## **SSDA 6799 MOD 1 - COLD STORAGE AND DISTRIBUTION FACILITY: RESPONSE TO SUBMISSIONS**

On May 18 2017 Urbis on behalf of Newcold submitted a Section 96 (2) Application to the New South Wales Department of Planning and Environment (DP&E) which sought to modify SSDA6799 to facilitate the use of the site by Newcold.

SOUTH ELEVATION
Scale 1:1000

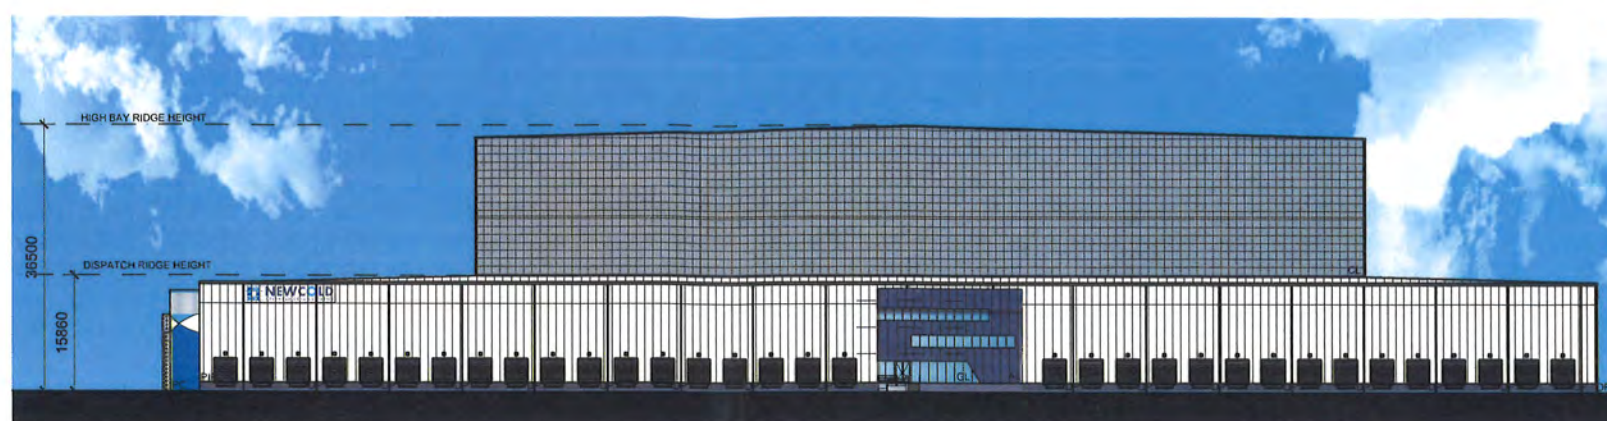
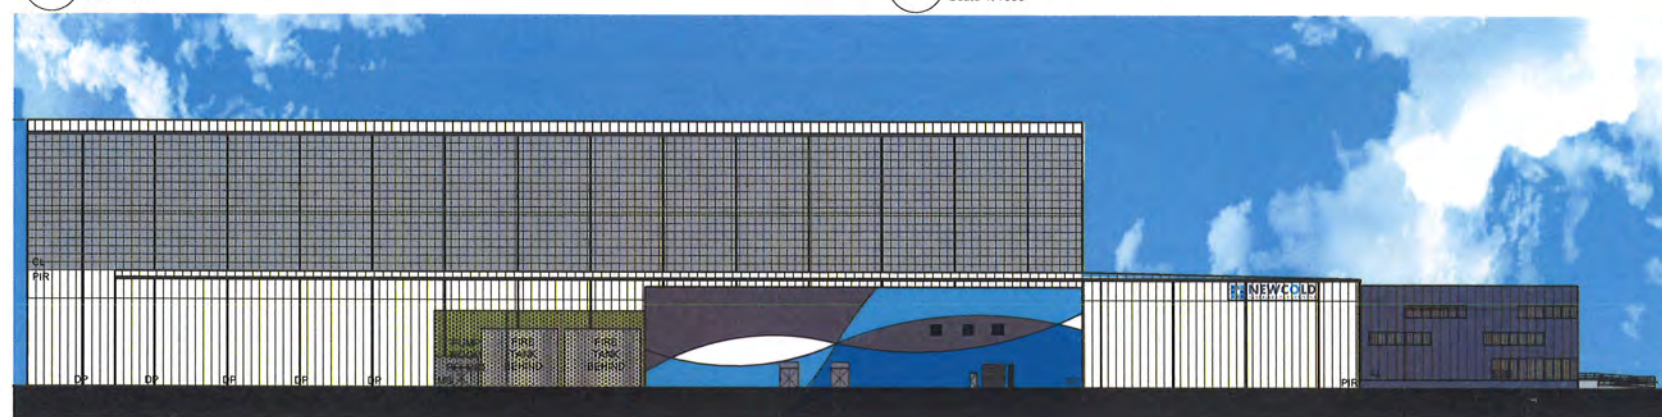
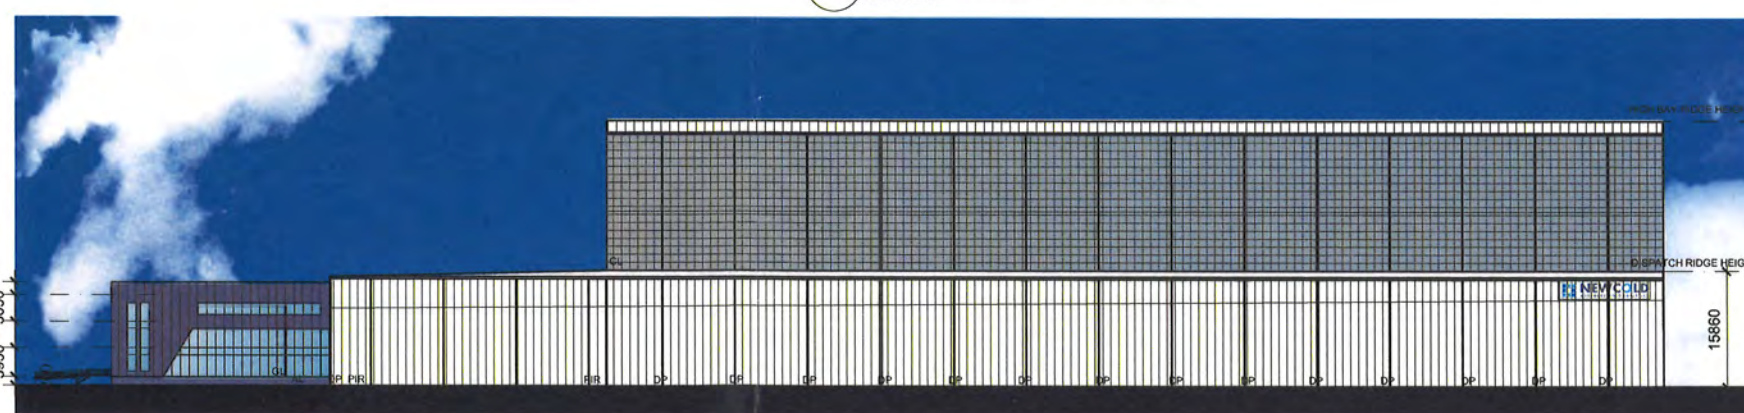
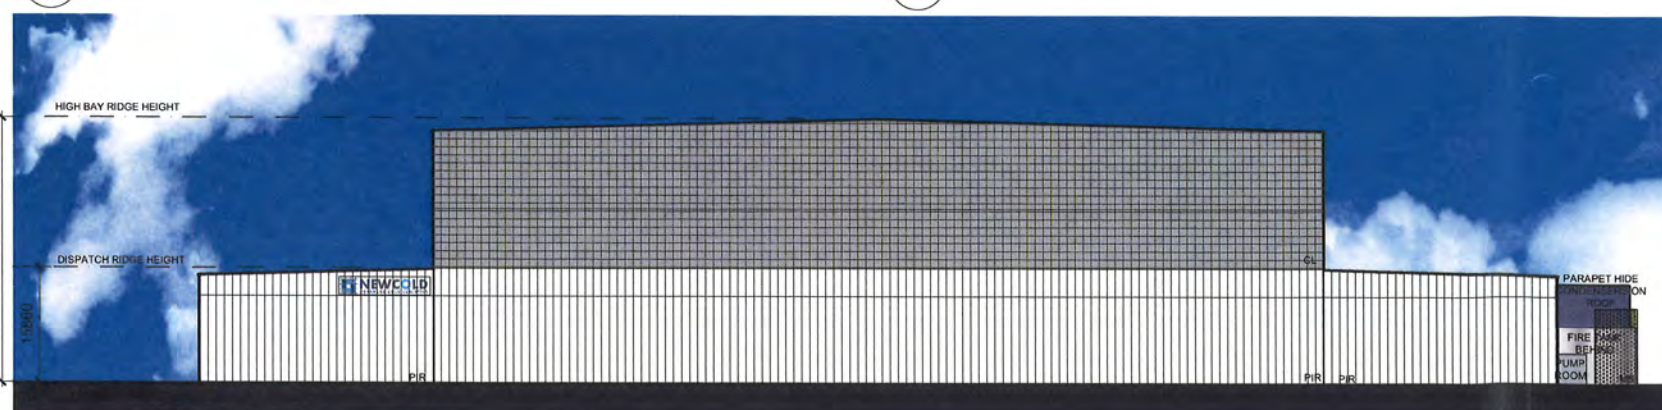
The building significantly exceeds the 16 m height limit that applies to the site. The external appearance and form of the building therefore requires careful detailing. Appropriate material selection is also required to ensure that the development contributes positively to its surrounding context and does not have an adverse impact on the intended scale and character of the area.

The office component of the development does not provide any additional visual interest on site. The office comprises standard curtain walling and metal cladding with no attempt made to exhibit any element of aesthetic interest.

It is considered that the controls and objectives of sections 6.4.2, 6.4.3 and 6.4.5 of the Marsden Park Industrial Precinct Development Control Plan (DCP) 2015 have not been satisfactorily addressed. For example, Clause 6.4.2 states that the built form and architecture of buildings located at street corners should enhance its location and positively respond to and emphasise the street corner. The applicant's submission (page 10 of the assessment table) responds to this requirement by stating that the "development site is not considered to be a corner site". The site, however, has 3 street frontages and is located in a prominent part of the estate on the corner of 2 sub-arterial roads. It is therefore considered essential that the design and appearance of the building enhance its significant location.

The design of the facility has subsequently sought to utilise a Kingspan Dri-design panel product. The finish creates a 3D effect and assists in distracting from the scale of the high bay warehouse without creating the further bulk that was shown in the previous design concepts.

The façade of the office portion of the building has been extensively revised in accordance with the comments received from BCC and is now considered to provide an appropriately articulated façade which provides an appropriate level of visual interest. Notably the façade of the office has been significantly augmented to include shading features and new materials to improve the overall look

Further consideration has been given to the design of the façade throughout its entirety to ensure that suitable articulation and visual interest is proposed. The amended scheme is therefore considered to appropriately consider the requirements of the Marsden Park Industrial DCP and the overall comments from Council.

SECTION A
Scale 1: 500

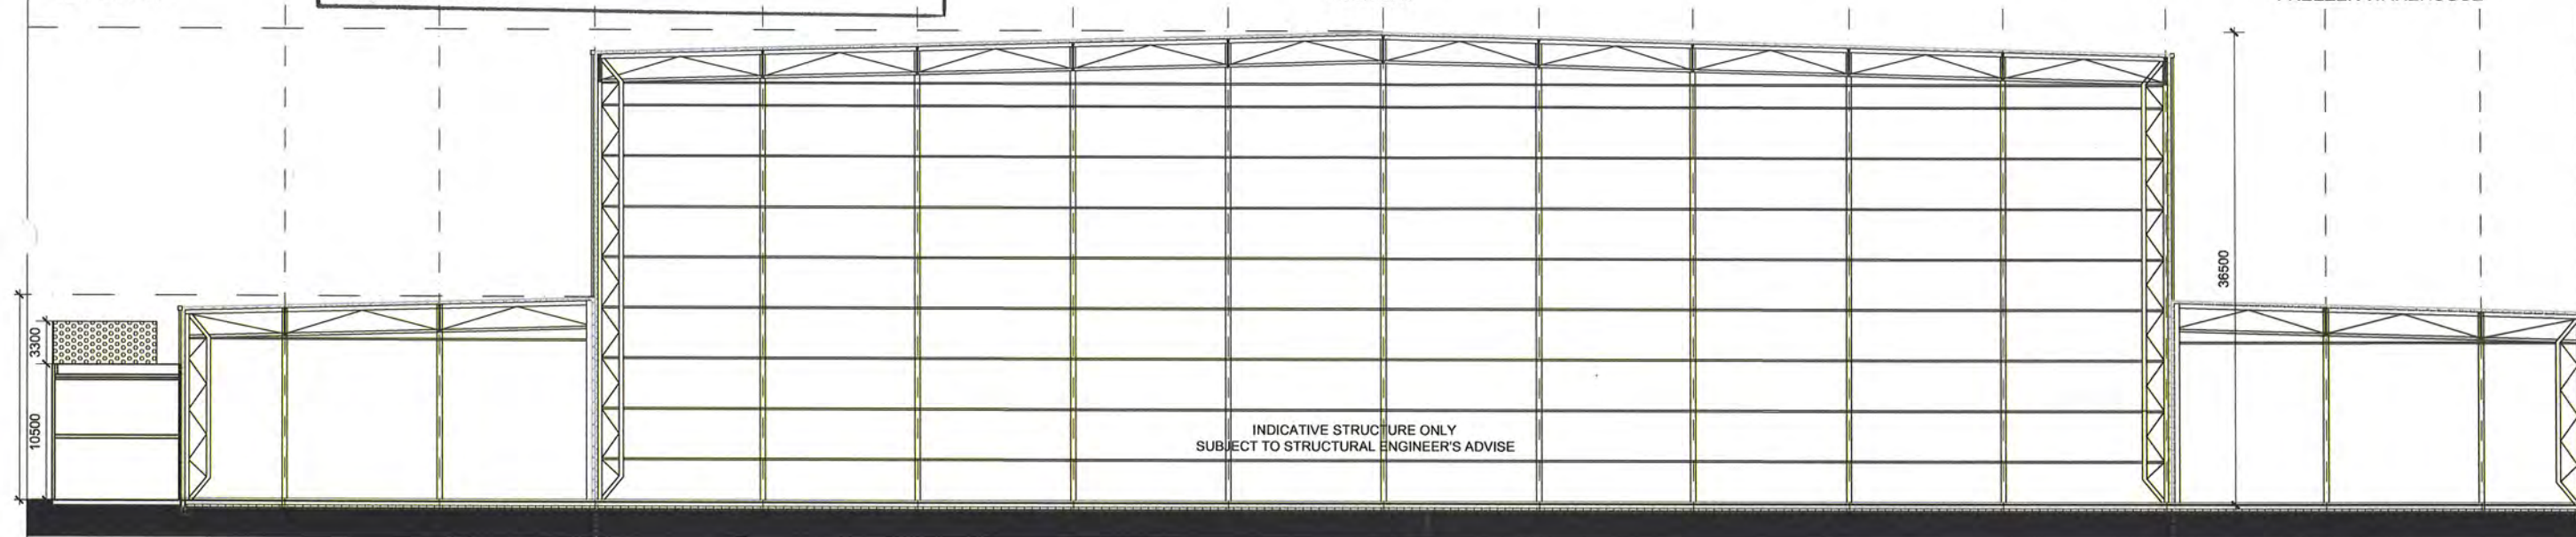
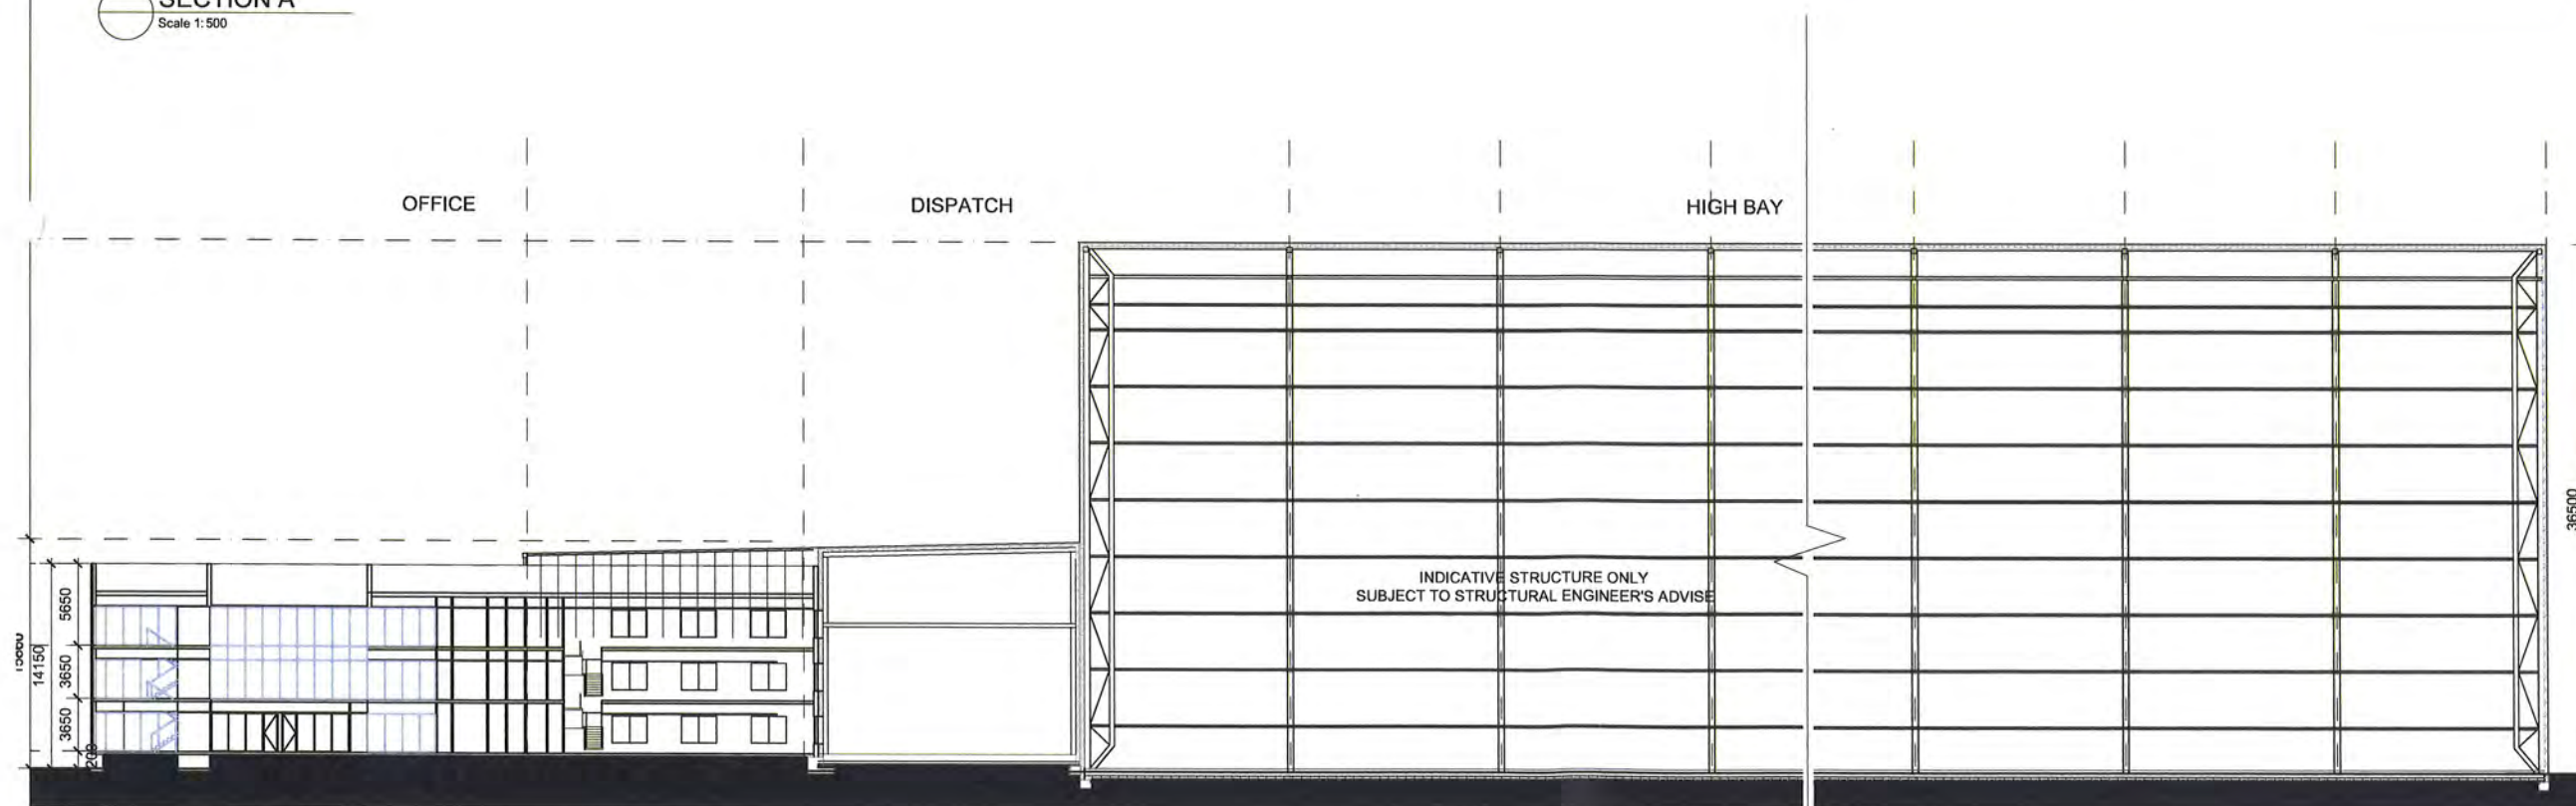
| Matters Raised                                                                                                                                                                                                                                                                                                                                     | Applicant consideration of matter/response                                                                                                                                                                                                                                                                                                                                                                                            |
|----------------------------------------------------------------------------------------------------------------------------------------------------------------------------------------------------------------------------------------------------------------------------------------------------------------------------------------------------|---------------------------------------------------------------------------------------------------------------------------------------------------------------------------------------------------------------------------------------------------------------------------------------------------------------------------------------------------------------------------------------------------------------------------------------|
| <p>The Modification Report states the proposed facility would have a Gross Floor Area (GFA) of 36,482 m<sup>2</sup>, however, the architectural plans submitted shows a building with a GFA of 37,682 m<sup>2</sup> . Please confirm the total building area of the proposed development and submit revised architectural plans, if required .</p> | <p>The proposed development will have a Gross Floor Area of 36,482sqm. This Gross Floor Area is comprised of the following:</p> <ul style="list-style-type: none"> <li>• High Bay Warehouse Area - 17,690sqm</li> <li>• Chiller Dispatch Area 3,714sqm</li> <li>• Freezer Dispatch Area 3,182sqm</li> <li>• Chiller Warehouse Area 4,256sqm</li> <li>• Freezer Warehouse Area 4,640sqm</li> <li>• Office Facility 3,000sqm</li> </ul> |

| Matters Raised                                                                                                                                                                                                                                                                                                                   | Applicant consideration of matter/response                                                                                                                                                                                                                                                                                                                                                                                                         |
|----------------------------------------------------------------------------------------------------------------------------------------------------------------------------------------------------------------------------------------------------------------------------------------------------------------------------------|----------------------------------------------------------------------------------------------------------------------------------------------------------------------------------------------------------------------------------------------------------------------------------------------------------------------------------------------------------------------------------------------------------------------------------------------------|
|                                                                                                                                                                                                                                                                                                                                  | <p>The two level tech room which has an area of 1,200sqm is considered to be a plant room and as such is not classified as Gross Floor Area under the definitions of State Environmental Planning Policy (Sydney Region Growth Centres) 2006</p> <p>It is noted that regardless of if the tech space is classified as Gross Floor Area or not the project will comply with the Floor Space Ratio prescribed to the site.</p>                       |
